STATE OF NORTH CAROLINA
DEPARTMENT OF TRANSPORTATION

Addendum No. 1

RE: Contract ID: C201562

Bridge over Richland Creek and
Approaches on SR-1930 (Stadium Drive).

PROJECT REFERENCE NO. **MA050018**
 SHEET NO. **U-1**

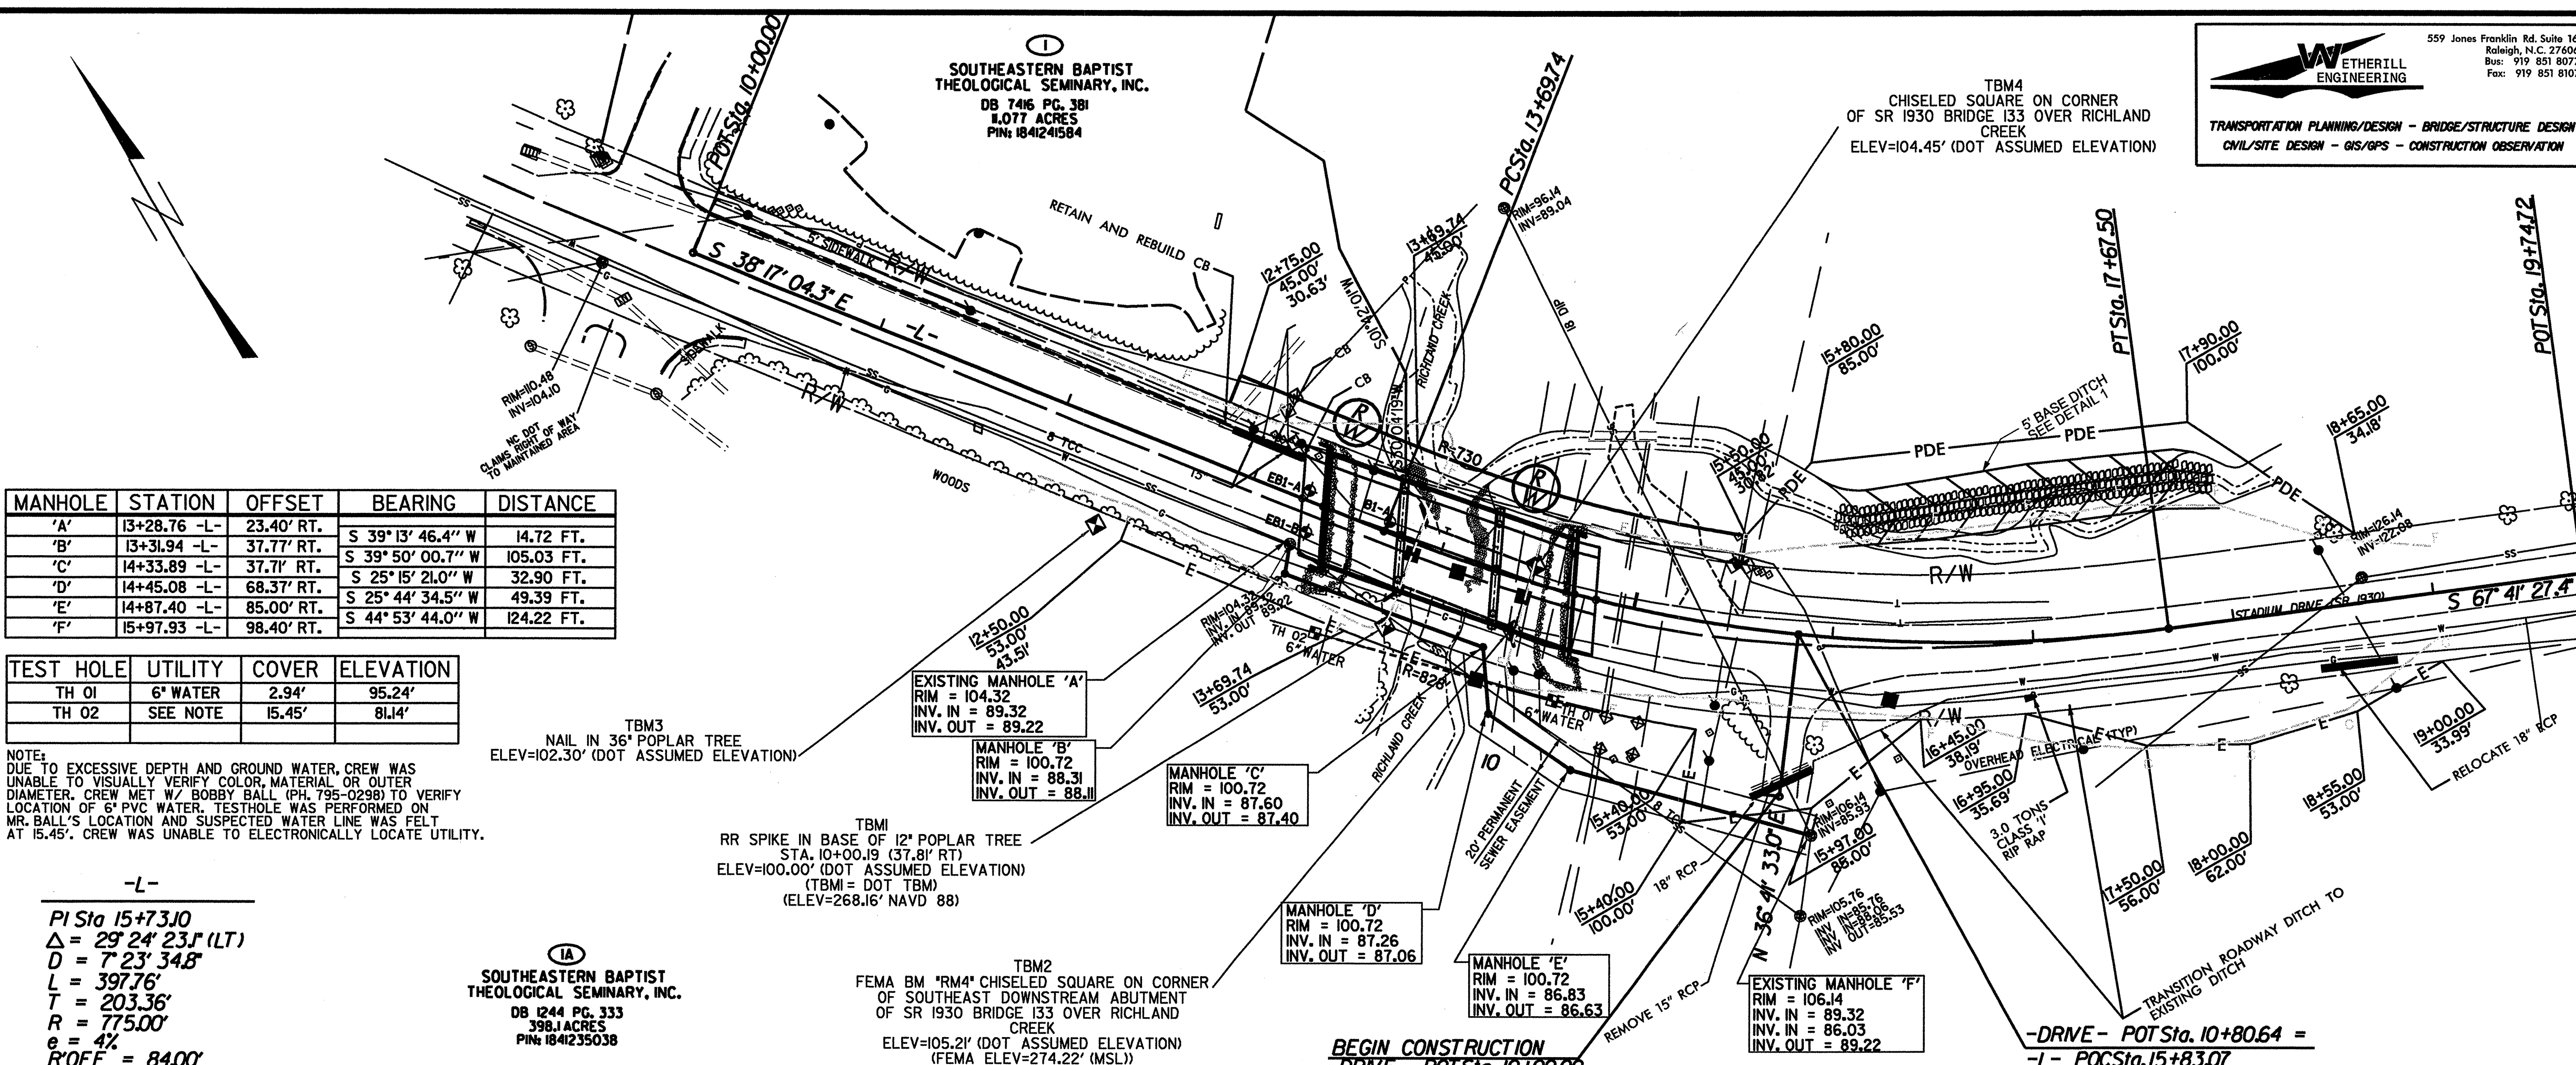
Plan Sheet No. U-1 And W-01 have been added. Please insert Plan Sheet No. U-1 And W-01 after Plan Sheet No. E-3 in your plans.

The work of this provision consists of replacing an existing sanitary sewer with a new sanitary sewer and providing a new water line for future use.

All work and materials shall conform to the plans, the City of Raleigh requirements for water and sewer, the NCDOT 2002 Standard Specifications, and the appropriate DENR regulations.

The existing sanitary sewer line shall be properly abandoned.
